Subject: FW: Attached letter from Kirklees Council regarding application number 2025/91184 at location land off, Bretton Street, Savile Town, Dewsbury, WF12 9BZ

Thank you for the consultation request. I have reviewed new documents of relevance to Designing Out Crime: Proposed site/ block layout (Drawing 110, Revision C, dated 28-10-2025), Landscape Proposals (Drawing 1001, Revision A, dated 06.10.25) and Landscape Maintenance & Management Plan (Document Ref: LMP 01 dated October 2025).

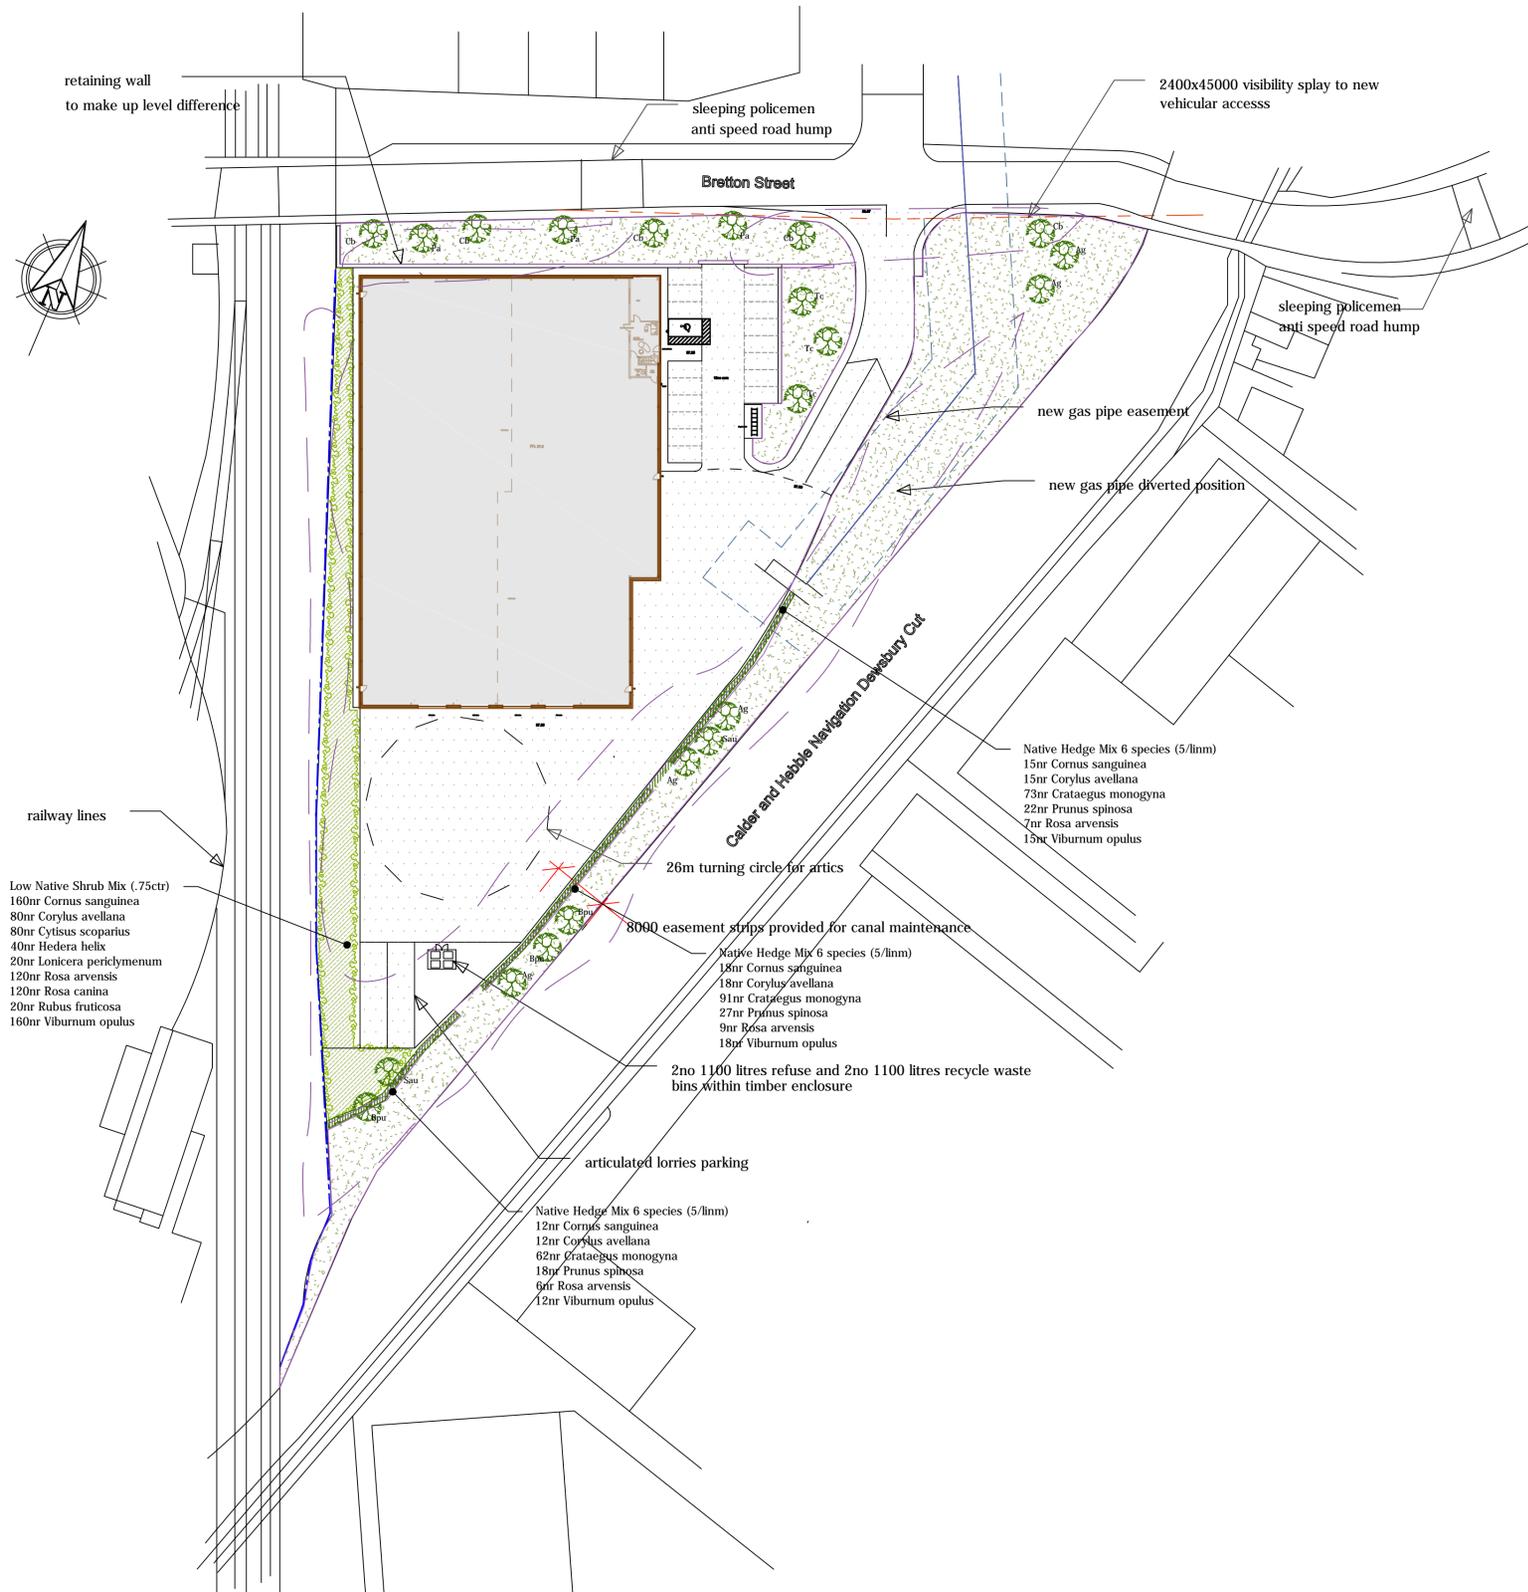
Landscape wise- the trees proposed at the rear of lorry parking spaces and parking bays opposite the building's entrance (images pasted below) should have clear stems and raised canopies (ideally to 2m) to enhance all-round visibility and supervision over the vehicles. The current proposed height for the trees is 1.8-2.1m- I would suggest that this is increased, if possible, to accommodate the above recommendation.
